DEVELOPMENT PLAN – 1ST REVIEW – APPROVED WITH COMMENTS

RE: PPR-17-046

On Friday, October 27, 2017, the Cimarron Hills Fire Department submitted plans to PEAK Consulting Services, Inc. for review of a development design for **HAMMERS SPEC new office/warehouse**, located at **1415 Selix Grove** in Colorado Springs, Colorado within the Cimarron Hills Fire Protection District.

6 FIRE LANE SIGN
SCALE: 1 1/2"=1'-0"

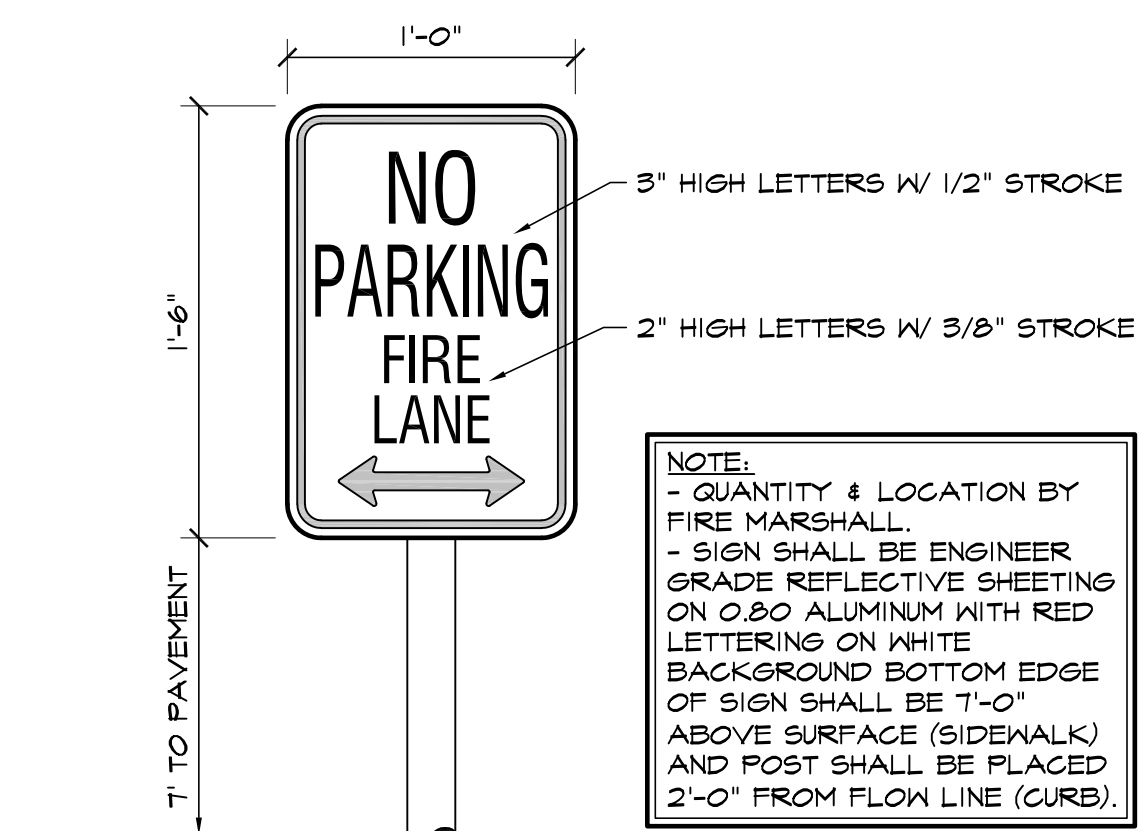
When signs are used to identify fire apparatus access roads, the signs shall comply with the IFC. Signs shall be permanent bearing the words "No Parking Fire Lane". Signs shall have a white background with letters and borders in red, using not less than two inch (2") lettering and have a minimum dimension of twelve inches (12") wide by eighteen inches (18") high. Signs shall provide directional arrows as applicable unless otherwise permitted. Signs shall be posted on one or both sides of the fire apparatus access road as required. Signs shall indicate the beginning and ending of the fire apparatus access road and shall be spaced no more than two hundred feet (200') apart. Additional signs may be required at changes in roadway direction.

1 SITE PLAN
SCALE: 1"=20'-0"

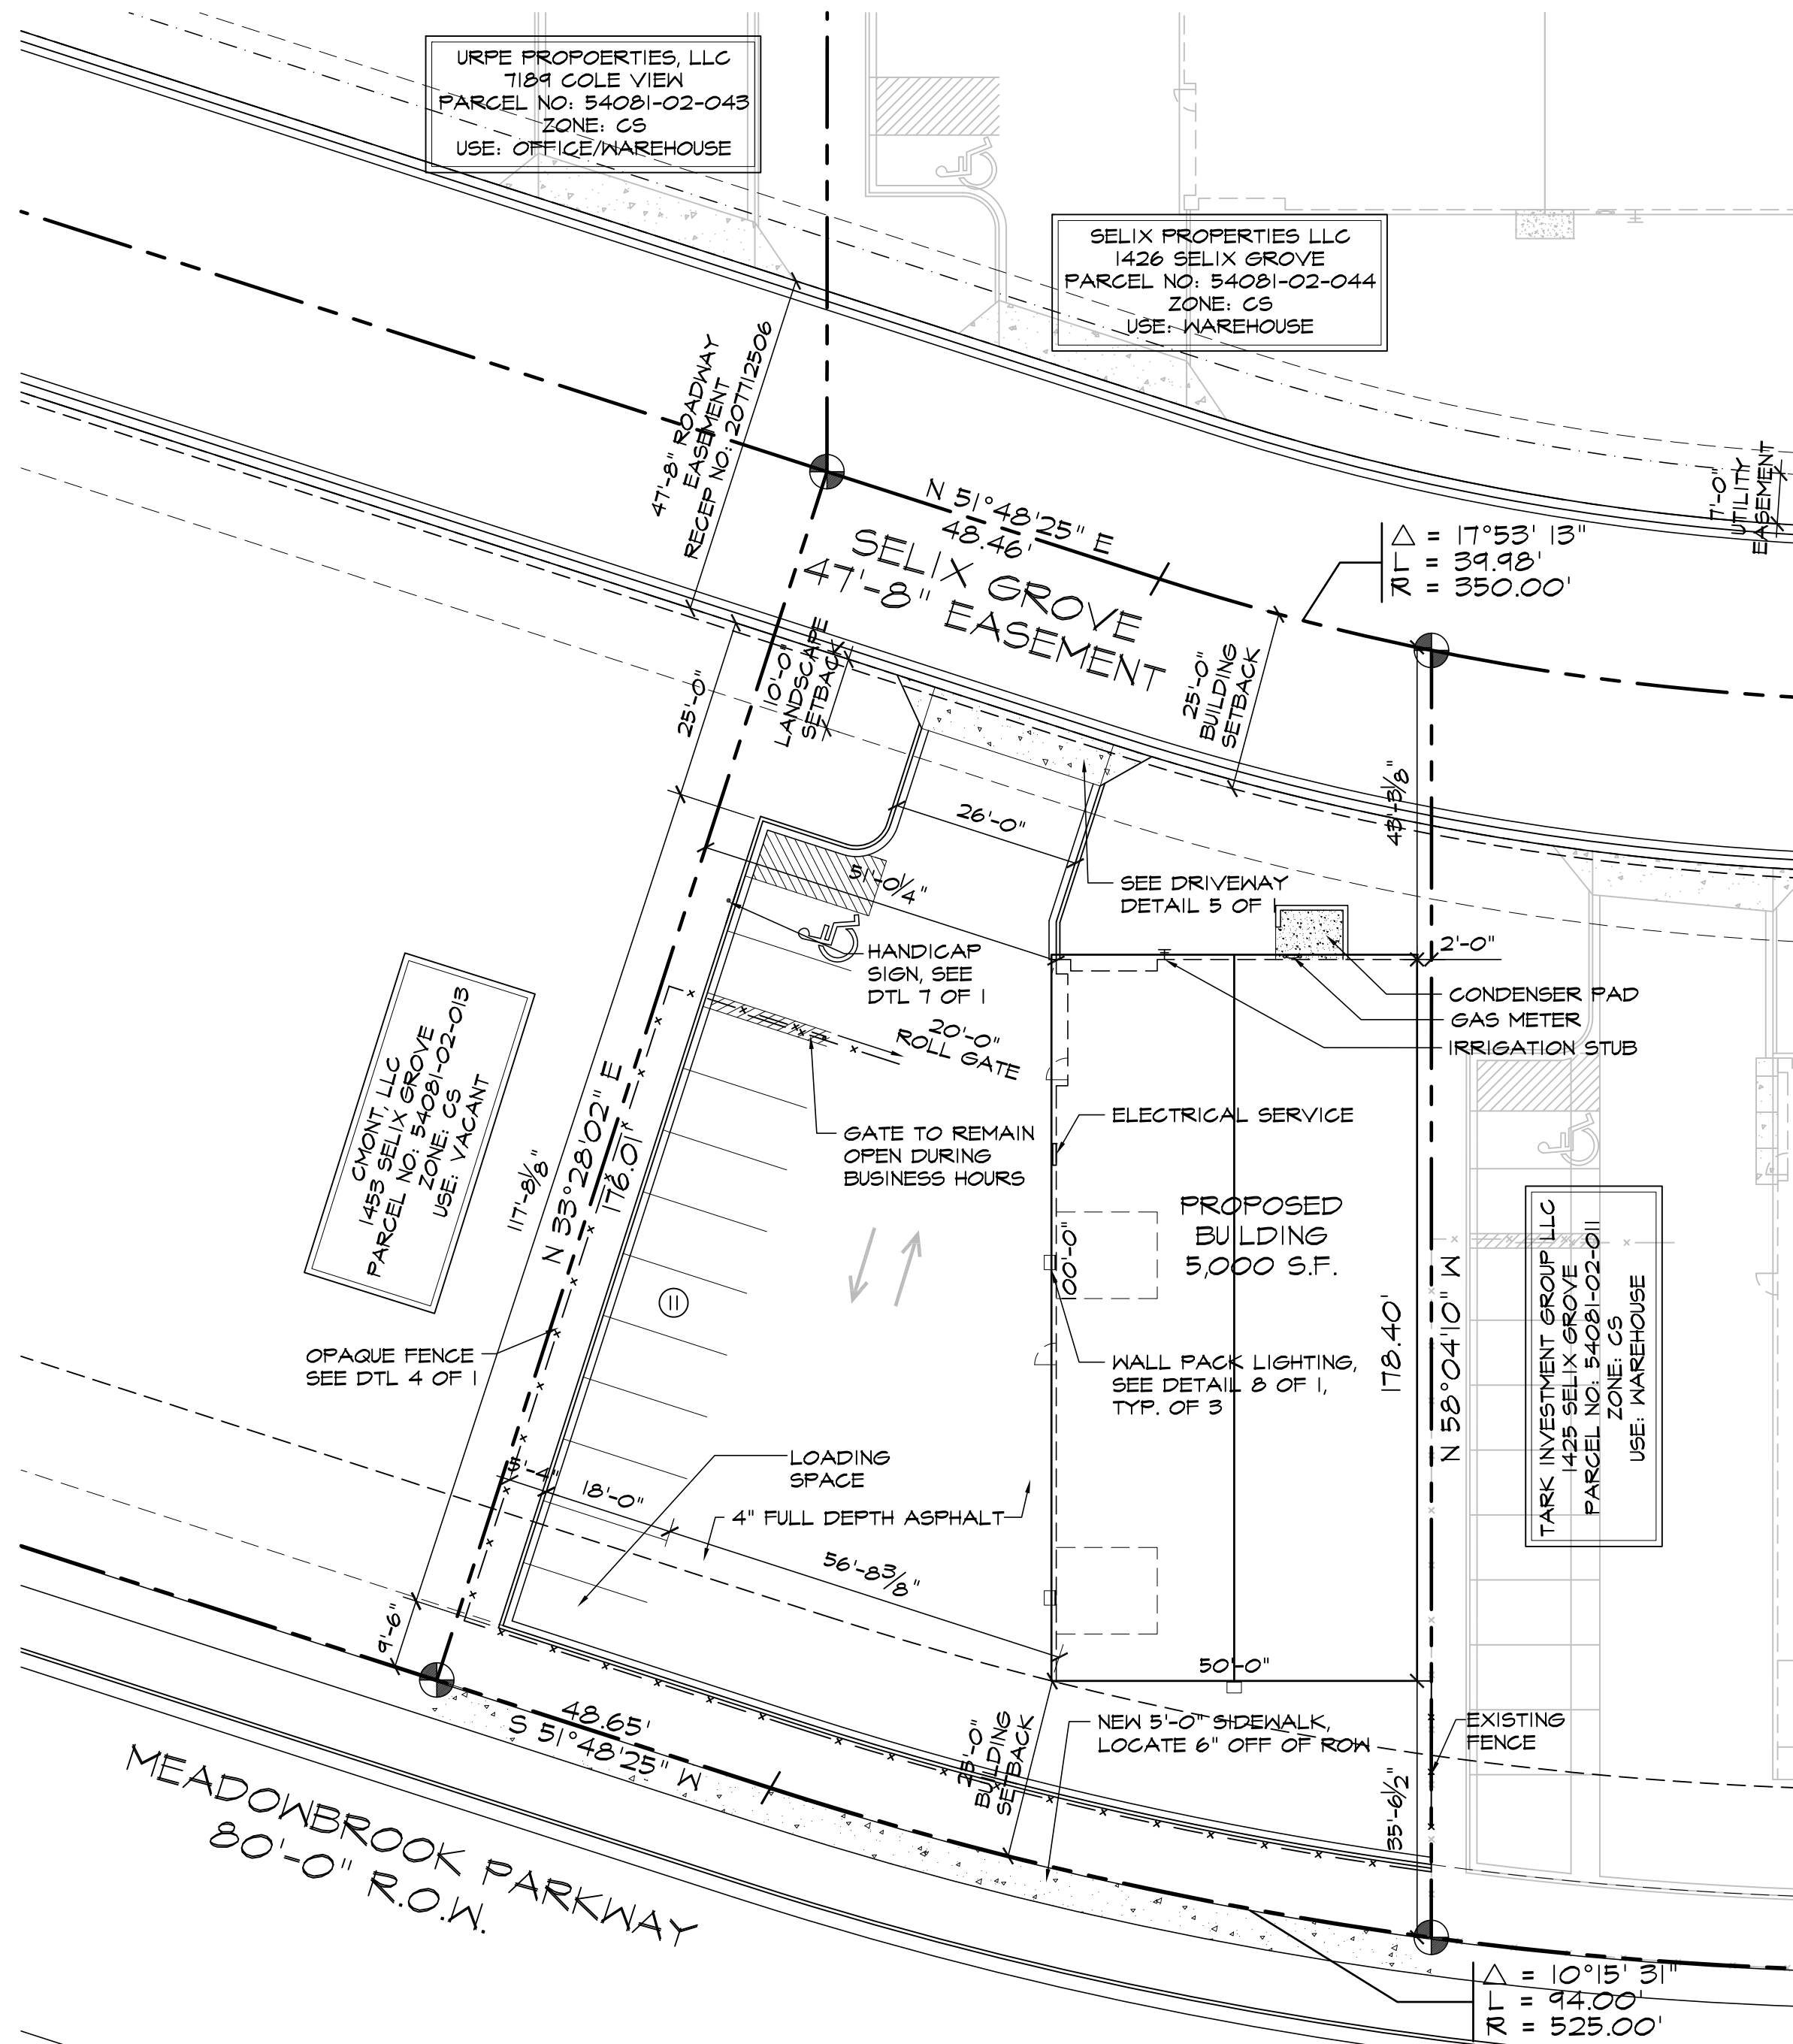
FIRE LANE: Fire lane signage shall be provided. Signs shall be a minimum dimension of 12-inches wide by 18-inches high and have red letters on white reflective background. Signs shall be posted on one or both sides of the fire apparatus road as required by the Fire Code.

150-FT ACCESS: Fire apparatus access roads shall comply with the requirements of the IFC. Fire apparatus access roads shall extend to within 150-feet of all portions of the facility and all portions of the exterior walls of the first story of the building as measured by an approved route around the exterior of the building or facility.

WIDTH: Fire apparatus access roads shall have an unobstructed width of not less than 20-feet except for approved security gates.

TURNING RADIUS: All fire apparatus access roads are to provide a minimum of 33-feet inside and 48-feet outside turning radius.
